**WELWYN HATFIELD BOROUGH COUNCIL
EXECUTIVE DIRECTOR - PLANNING, PUBLIC PROTECTION AND GOVERNANCE**

DELEGATED APPLICATION

Application No: 6/2022/2146/ADV
Location: H R Owen Mosquito Way Hatfield Hertfordshire AL10 9WN
Proposal: Installation of signage to facade of east and west buildings together with site wide totem wayfinding signage
Officer: Ms Elizabeth Mugova

Recommendation: Granted

Drawing Title
East Building Elevations with Proposed Signage Sheet 2

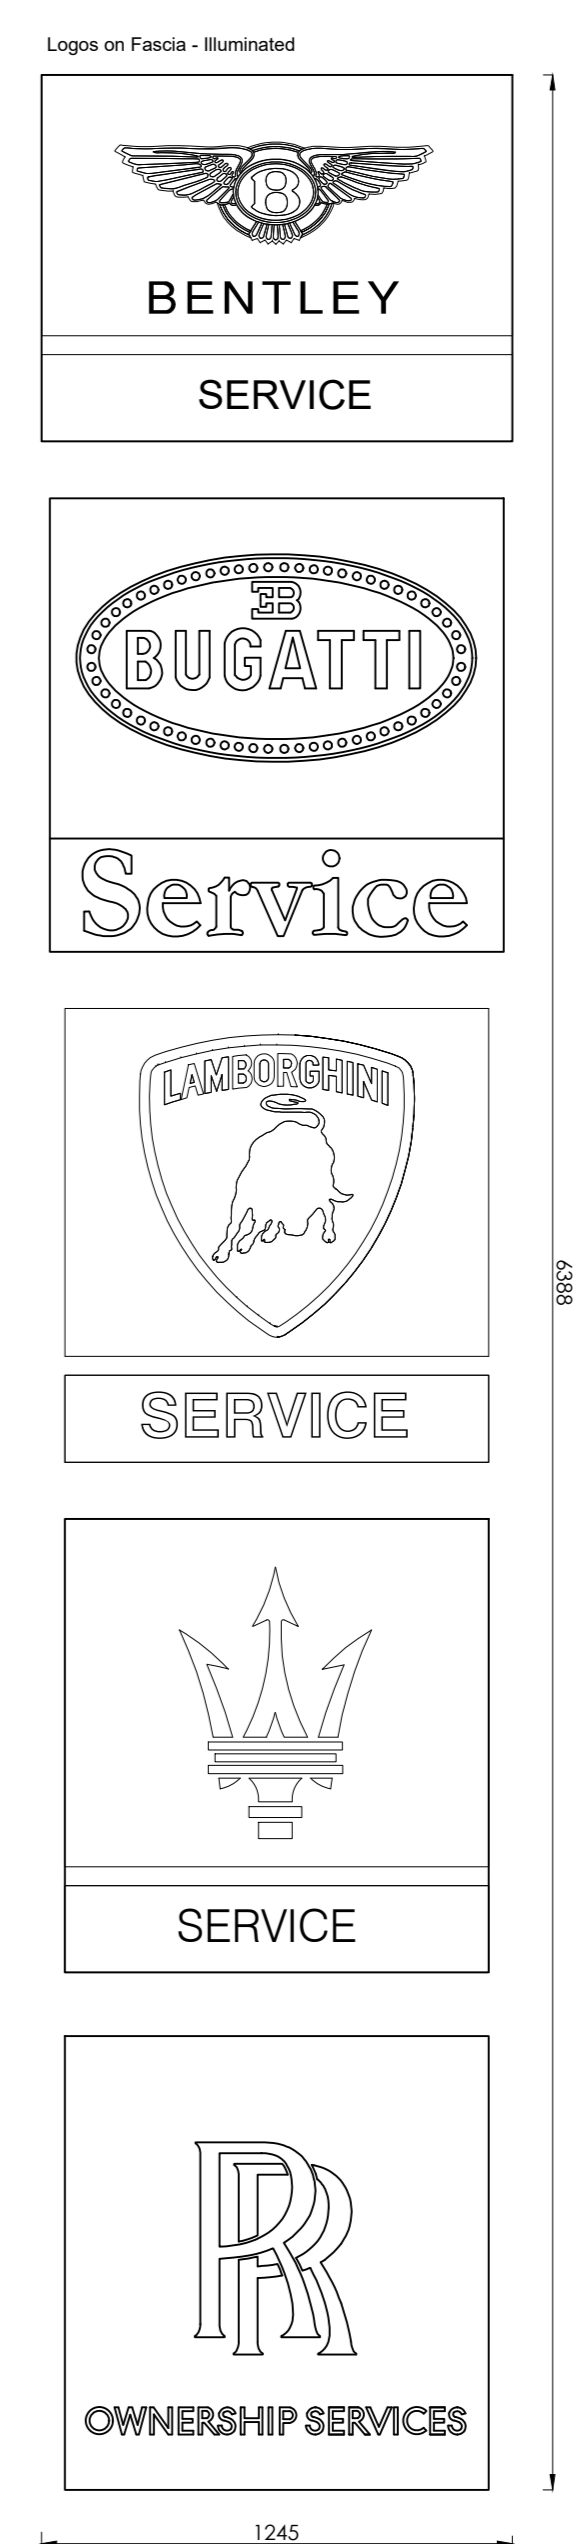
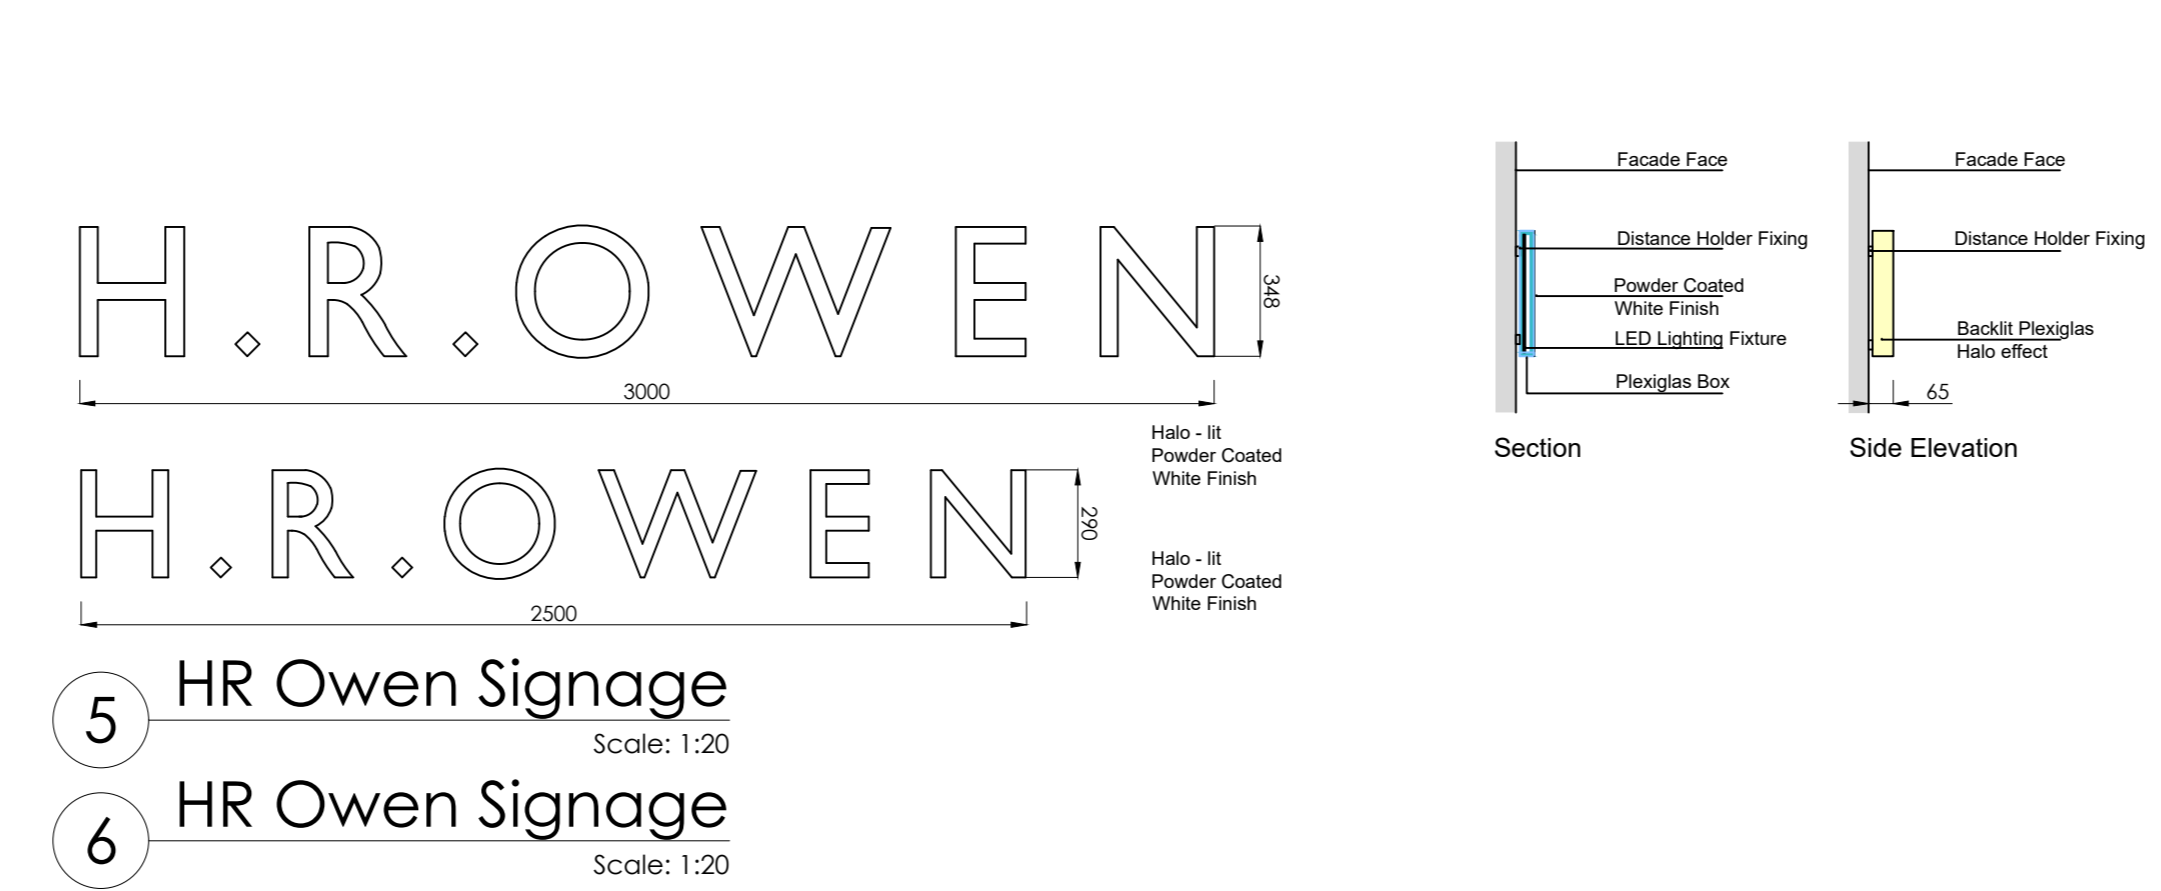
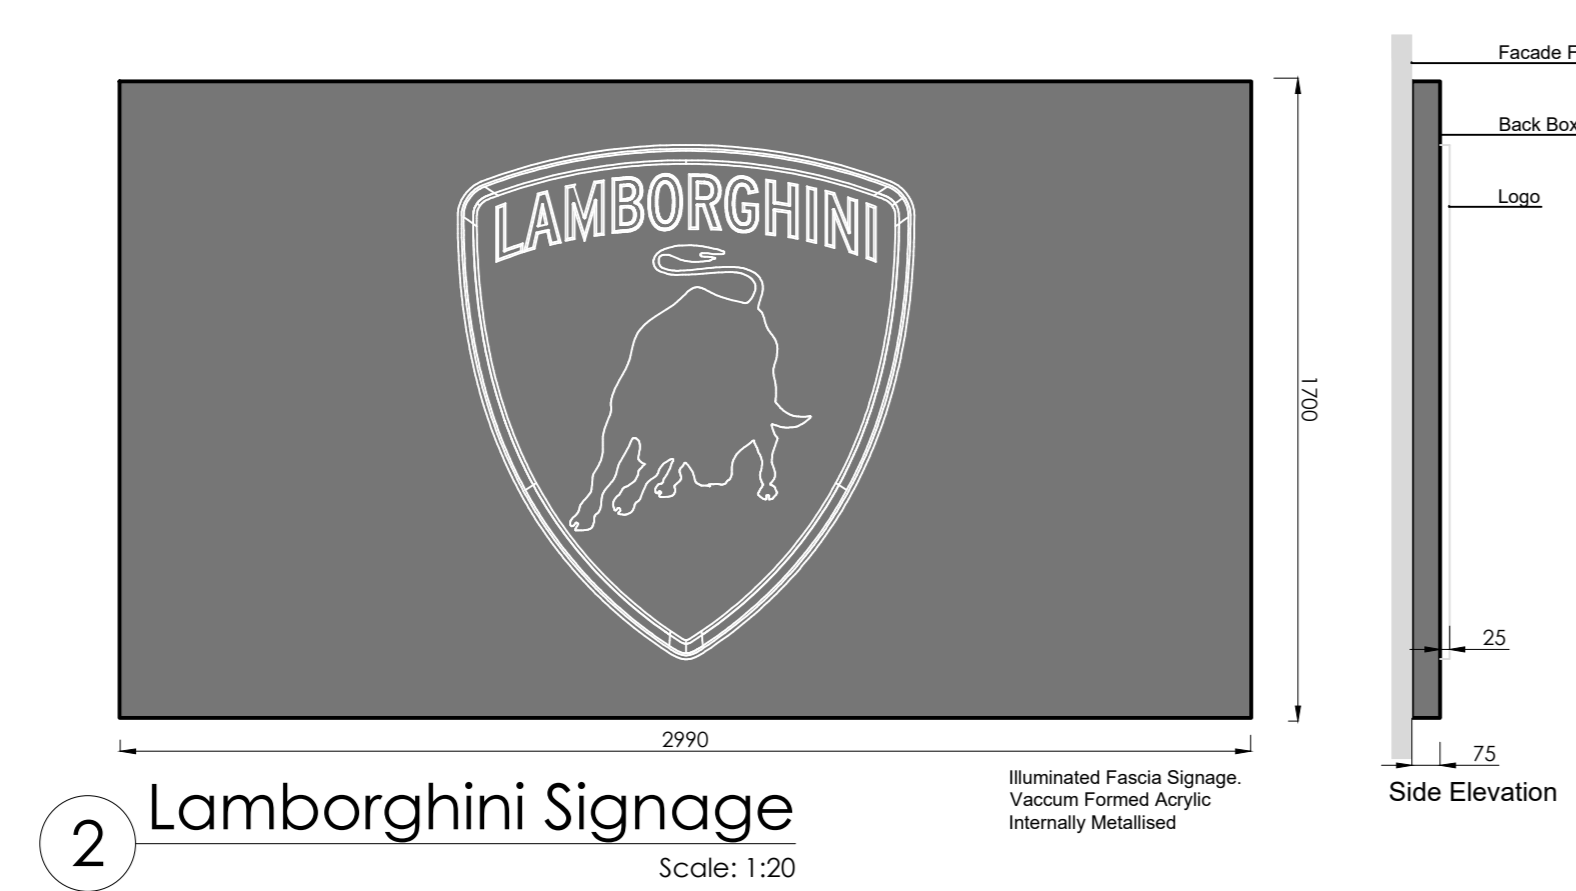
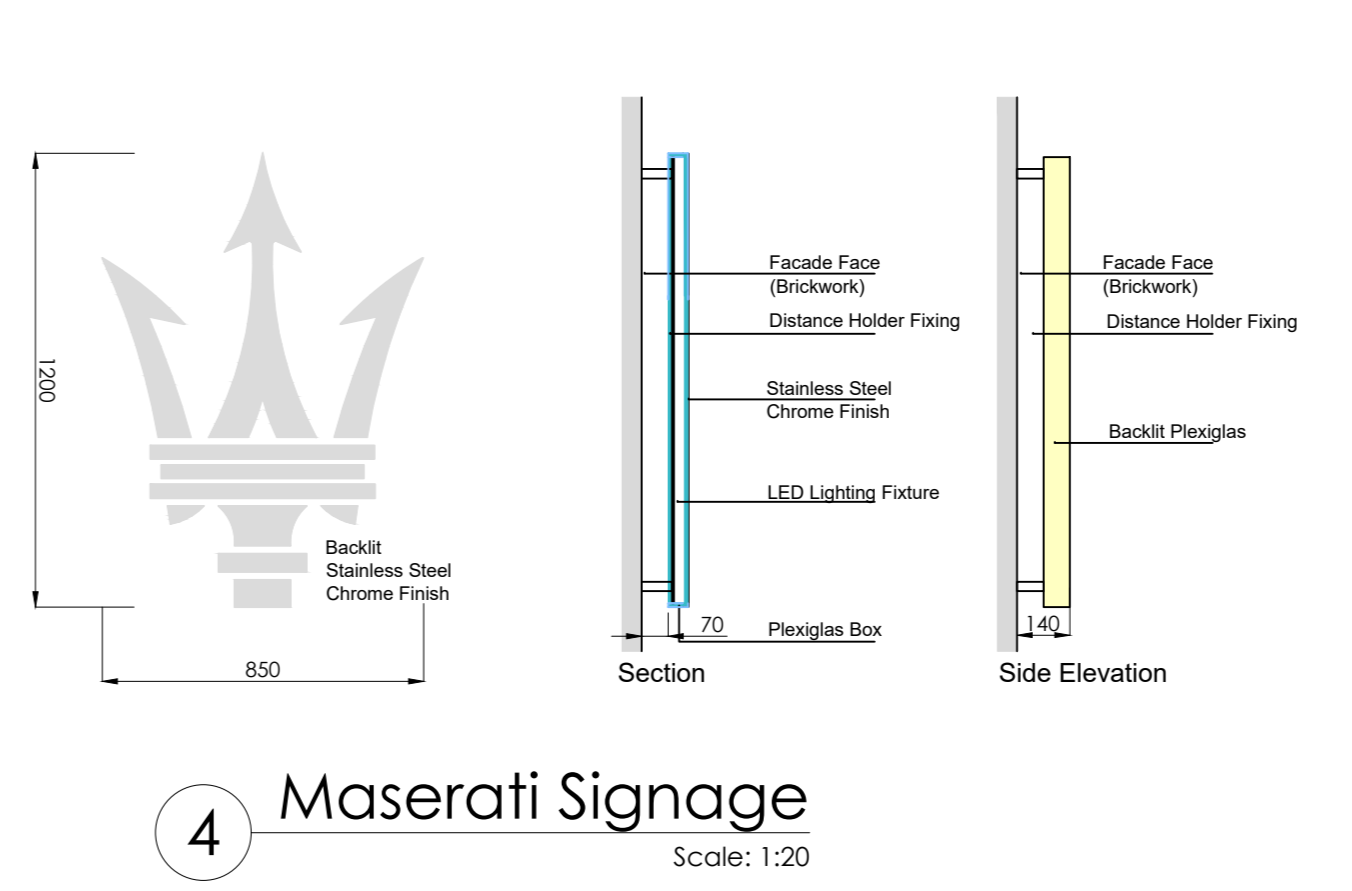
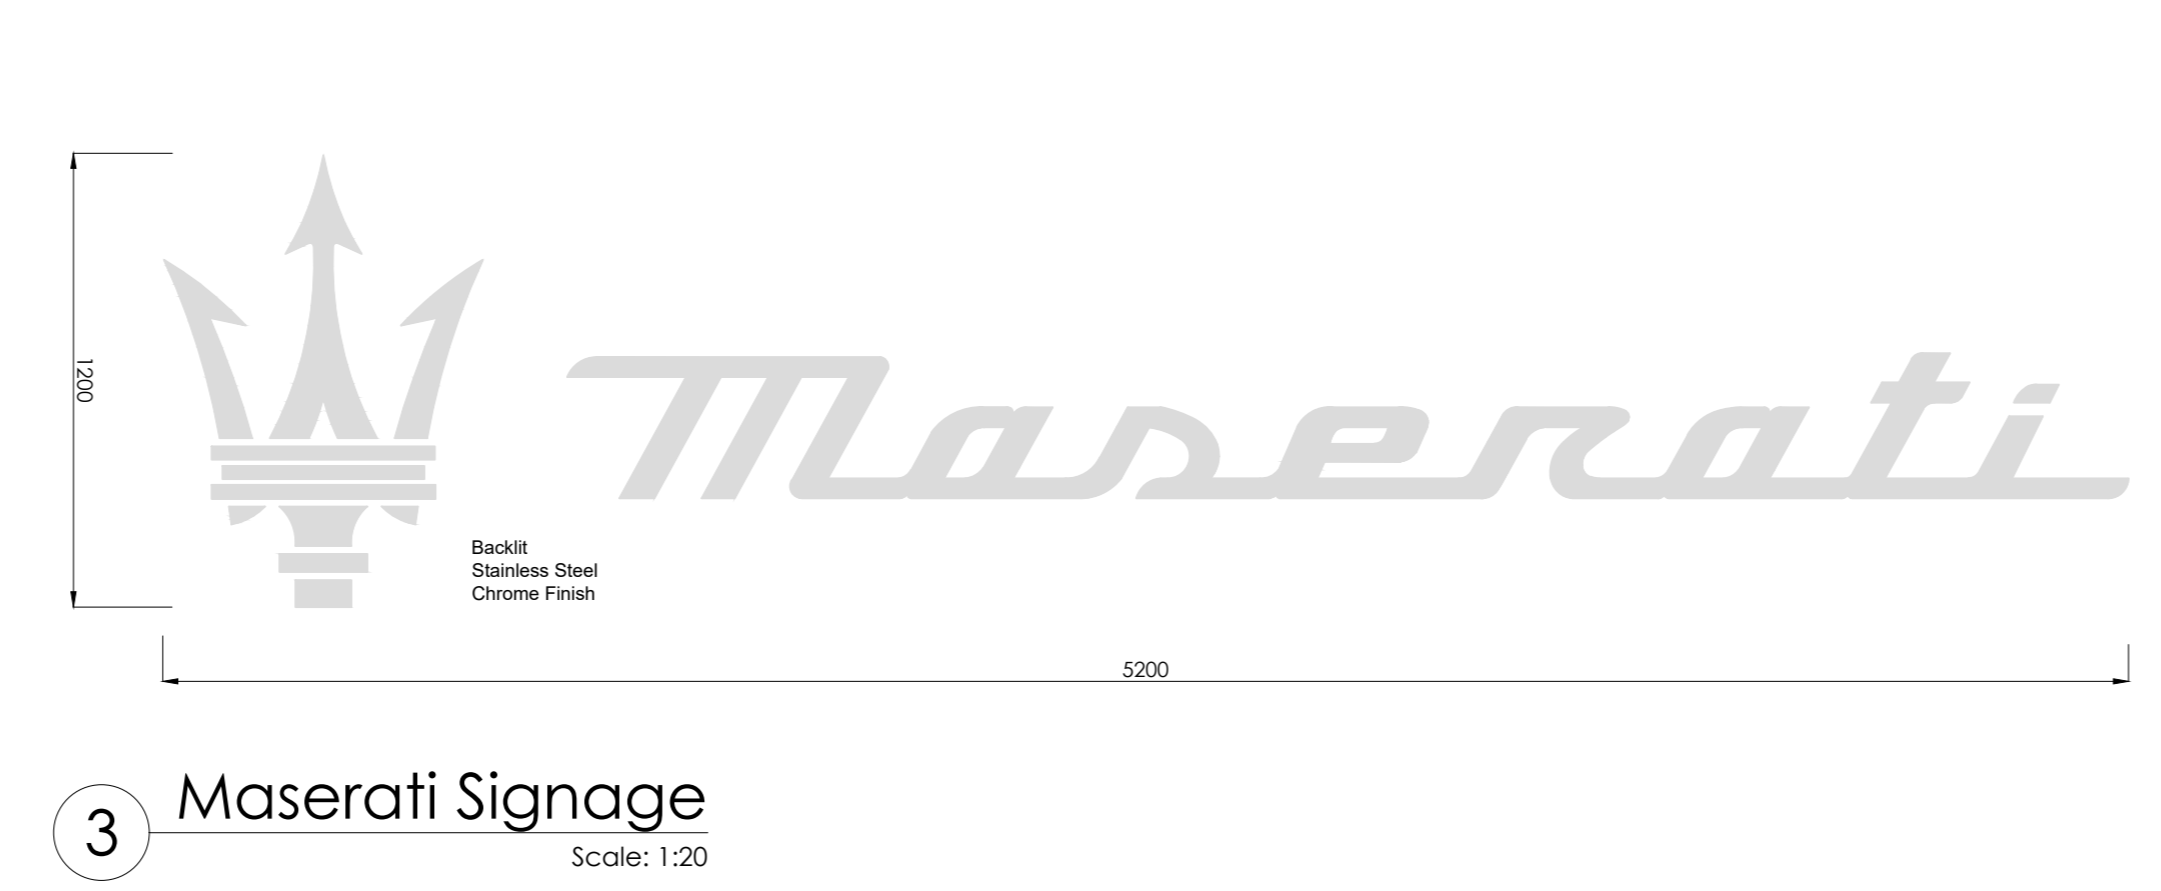
It is assumed that the LED screens will be used in relation to the garages below them rather than to advertise as they are not aimed directly at the highway. They will, however, be visible to drivers heading north-east on Mosquito Way and the style and speed of the intermittent images should be considered to ensure they are not distracting the drivers. It has therefore been considered appropriate and necessary to attach a condition to ensure that passing drivers are not distracted by the LED screens.

1. All LED displays must:
 - a) Have no moving images, animation, video or full motion images unless specific consent has been granted for such displays;
 - b) Not change more frequently than every 5 seconds unless specific consent has been granted for such displays;
 - c) Comply with the luminance limit as outlined in the Institution of Lighting Engineers in the publication 'Technical Report No 5: Brightness of Illuminated Advertisements' (2003); and
 - d) Not feature any signs or instructions contained within the Traffic Signs Manual (2018) and Traffic Signs Regulations and General Directions 2016 and any subsequent guidance, or any variation of these signs which would otherwise cause confusion with traffic signs or signals.
